Appeal Decision

Appeal Ref: 6009626

54 Meltham Road, Huddersfield HD1 3UP

- The appeal is made under section 78 of the Town and Country Planning Act 1990 (as amended) against a refusal to grant planning permission.
 - The appeal is made by Bilal Altaf against the decision of Kirklees Metropolitan Council.
 - The application Ref is 2026/62/90733/W.
 - The development proposed is a change of use from dwelling (C3 use) to form 2no residential apartments (C3 use).
-

Project No. 2026 Enquiry 06	Project Title Existing and proposed cross section	Scale 1:100 @A3 size	Date 2/3/2026
Drawn By	Reviewed By MC		
Drawn No. 102	Reviewed Title		Revision

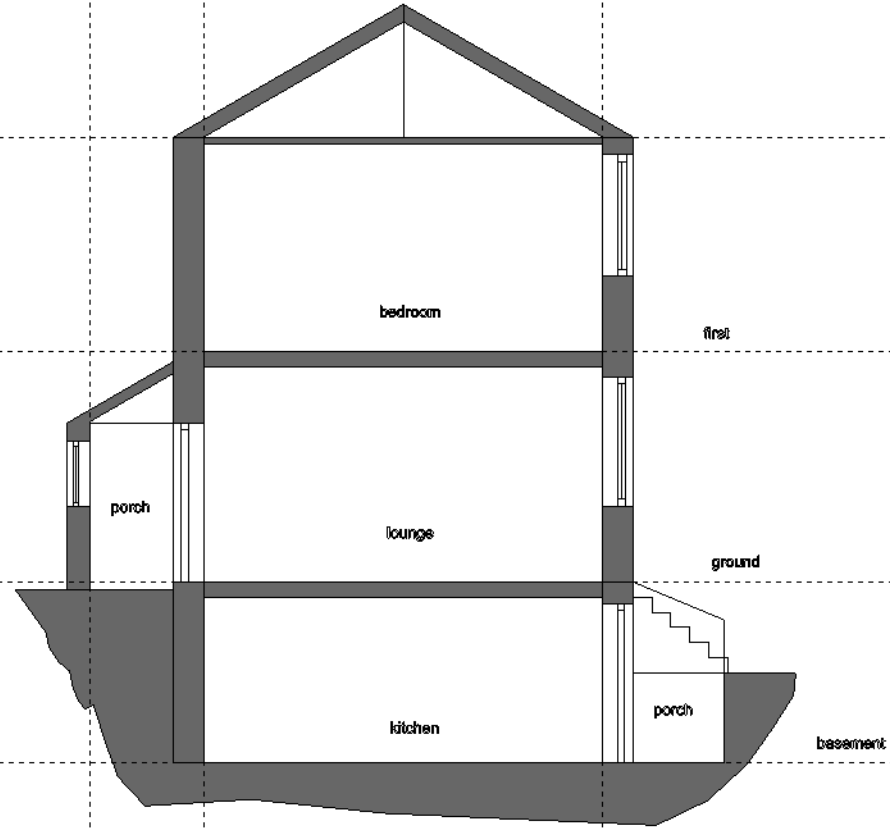
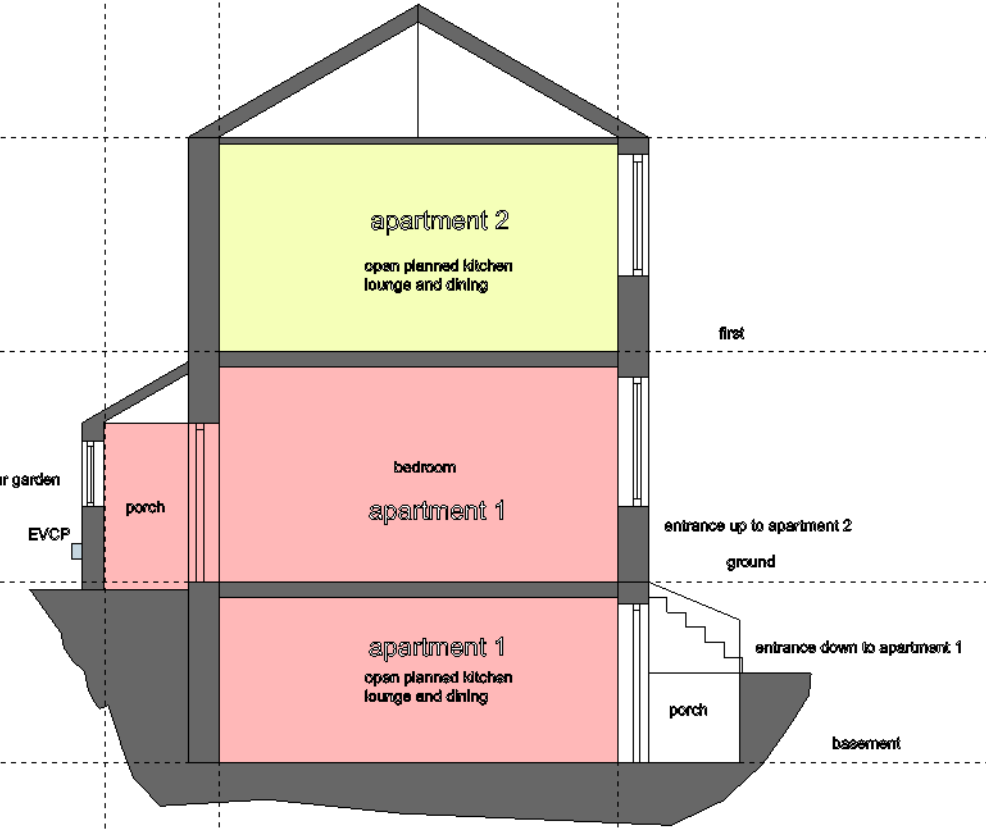
7. Furthermore, due to the basement's subterranean position, the outlook from this window would face onto the retaining brick wall of the front garden. This would further restrict the amount of daylight capable of reaching the window and the living accommodation it would serve. Consequently, the main living area would receive a very limited level of natural daylight and would appear enclosed, with a poor outlook. The occupiers of Apartment 1 would likely have to rely heavily on artificial lighting throughout much of the day.

Project Title
proposed cross section

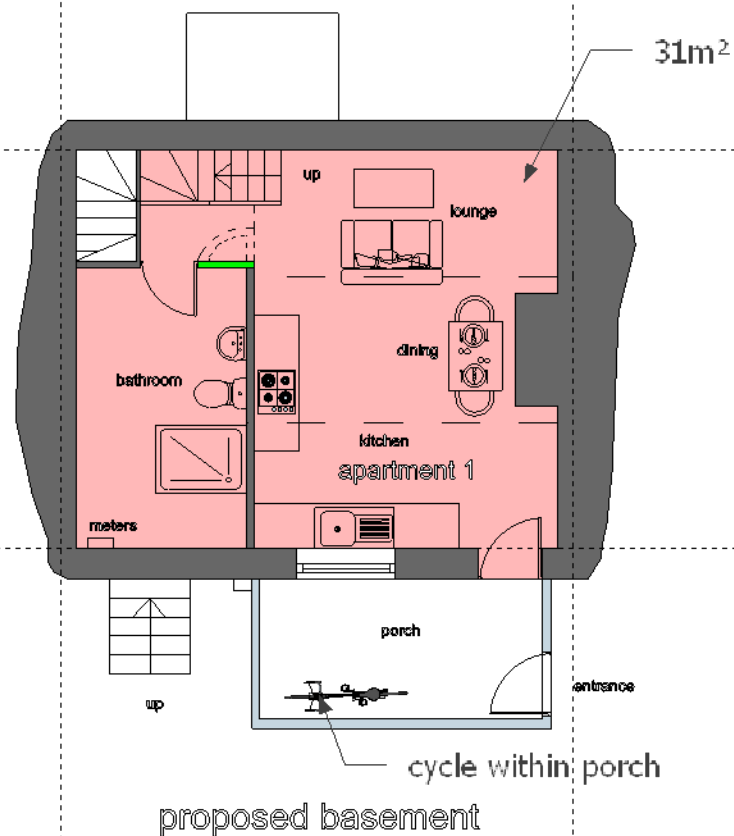
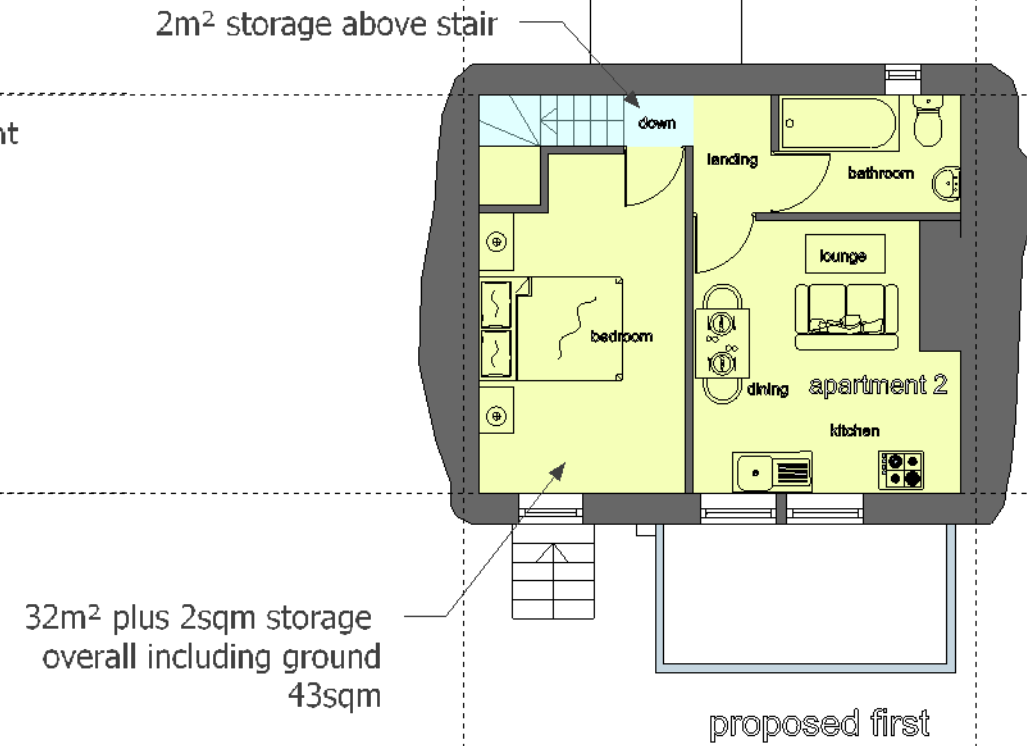
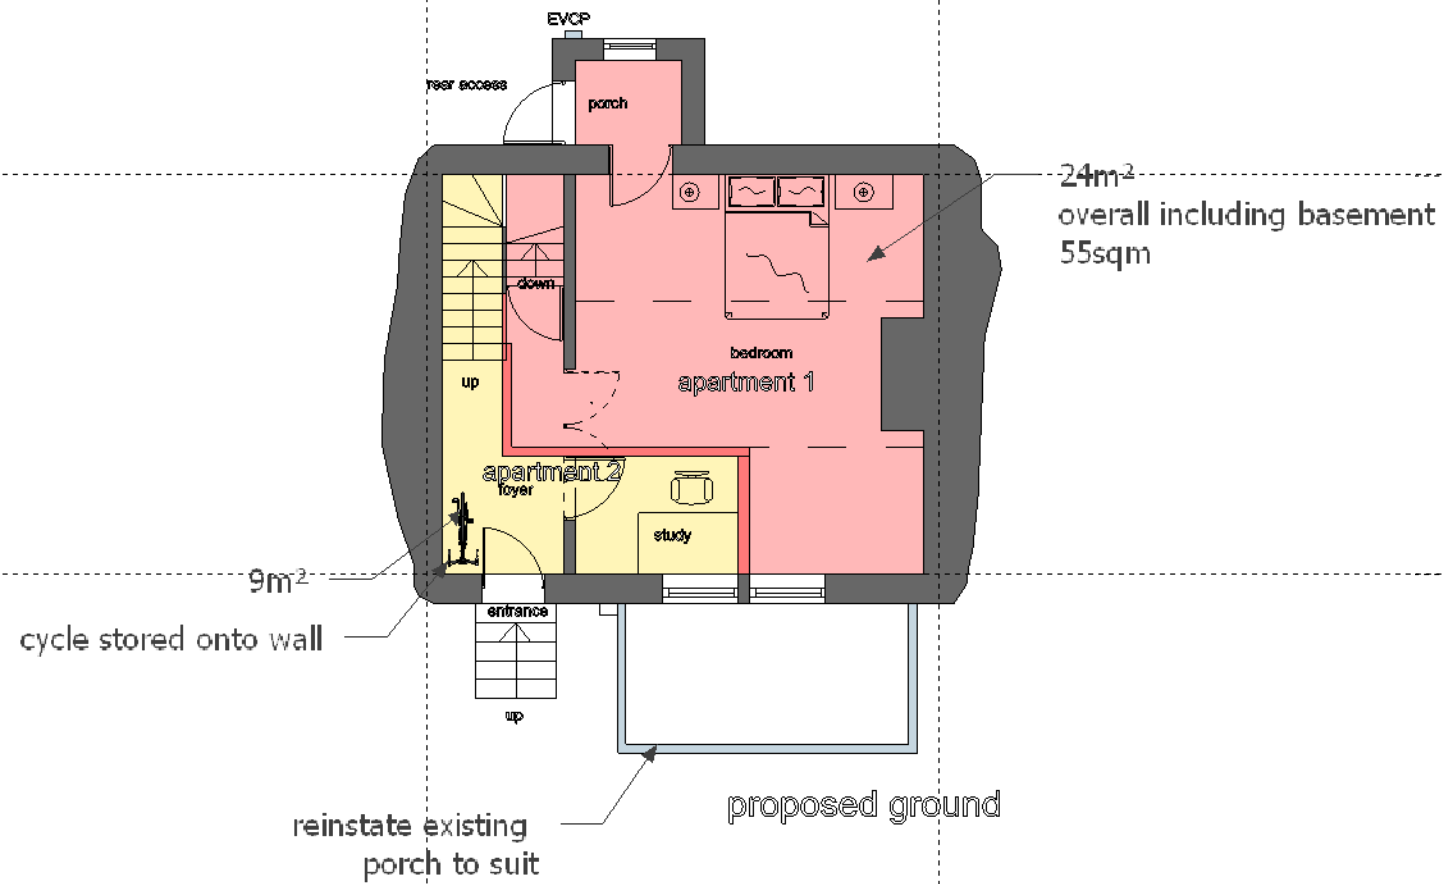
5. The appeal property is a mid-terraced dwelling with a basement level. It is proposed to subdivide of the existing dwelling to create two self-contained apartments, each over two levels with separate accesses.
6. As well as expressing concern about the floor space of the flats against the Nationally Described Space Standards (NDSS) which I shall come onto, I take it from the Council's evidence that their other concerns translate to a lack of an acceptable level of daylight and poor standard of outlook to the basement living accommodation for Apartment 1. This area would rely on a single window in the front elevation as its only source of natural daylight. The submitted plans indicate

that this window would also be positioned behind a porch structure, meaning that any daylight entering the room would be filtered through that space.

9. Nevertheless, even if I were to reach a favourable conclusion regarding the amount of floorspace provided and the application of the NDSS, this would not overcome my concerns regarding the poor levels of natural daylight and outlook afforded to the occupiers of Apartment 1. Those shortcomings would remain and would, in themselves, result in unacceptable living conditions for future occupiers.
